DOC19/531413
SSD 9522

Notice of Exhibition - Kemps Creek Warehouse, Logistics and Industrial Facilities Hub at 657-769 Mamre Road, Kemps Creek (SSD 9522)

Attachment A**EES comments on Notice of Exhibition - Kemps Creek Warehouse, Logistics and Industrial Facilities Hub at 657-769 Mamre Road, Kemps Creek (SSD 9522)**

Figure 4.3: Survey effort.

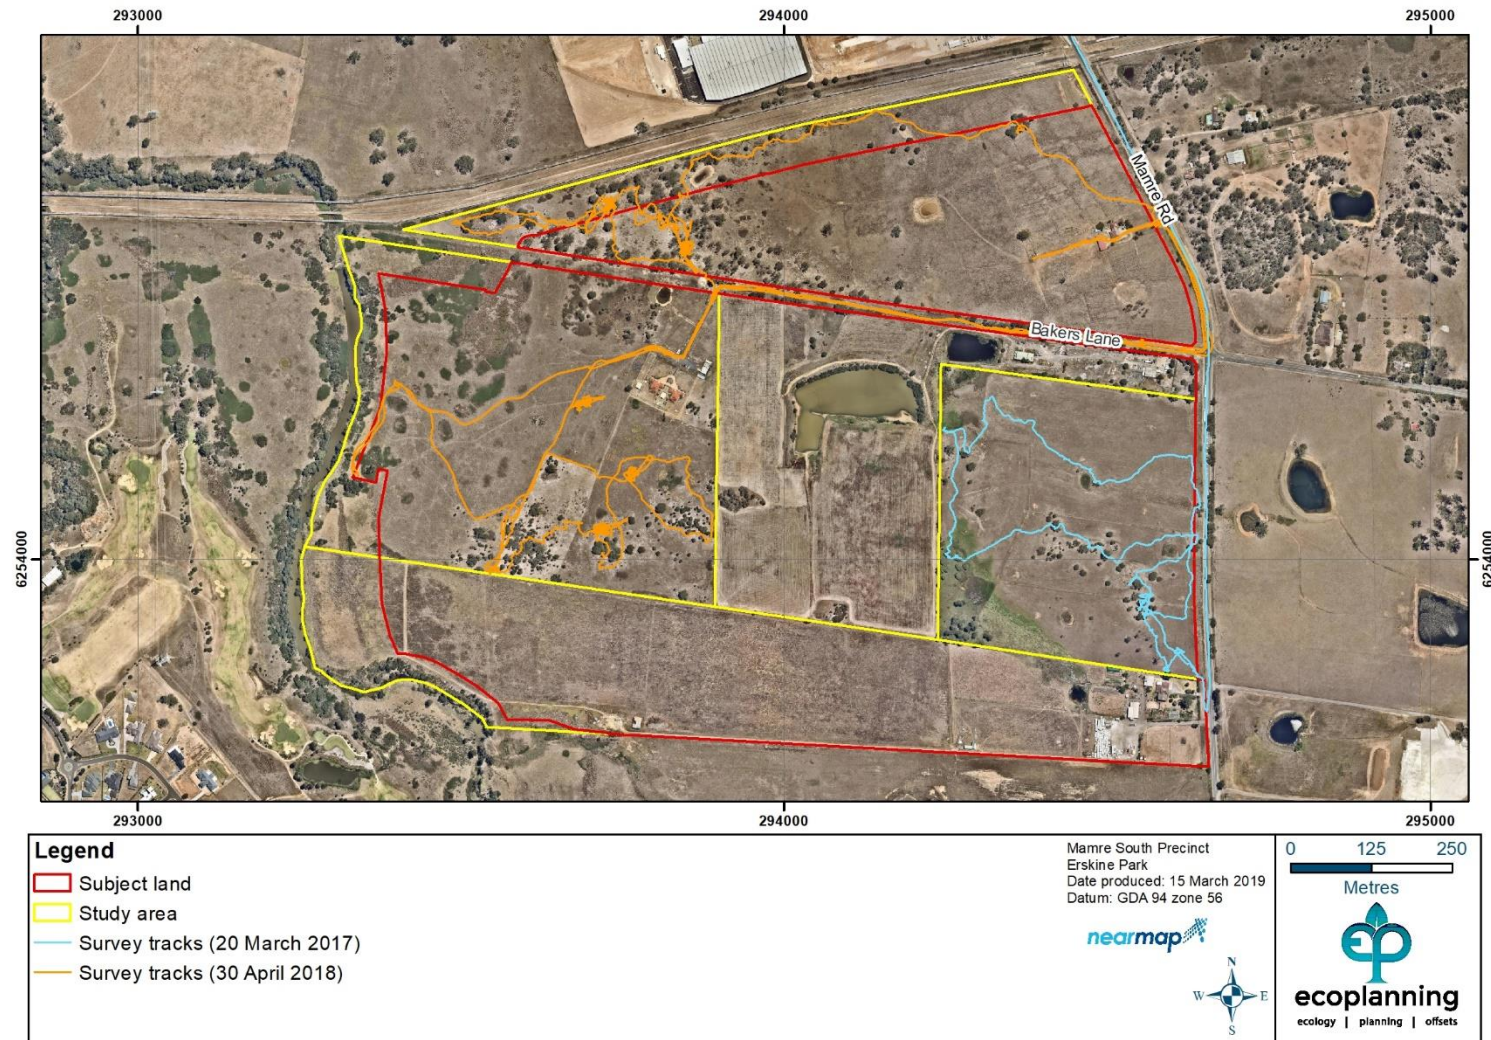
Section 4.3 of the BDAR then notes that the other 15 “Confirmed candidate species will need to be assessed consistent with Steps 4 – 6 of Section 6.4 of the BAM and targeted surveys for species credit species should be undertaken in accordance within section 6.5 of the BAM”. However, Figure 4.3 of the BDAR confirms that most of the site has not been surveyed in accordance with the BAM, in that targeted surveys for species credit species were not undertaken.
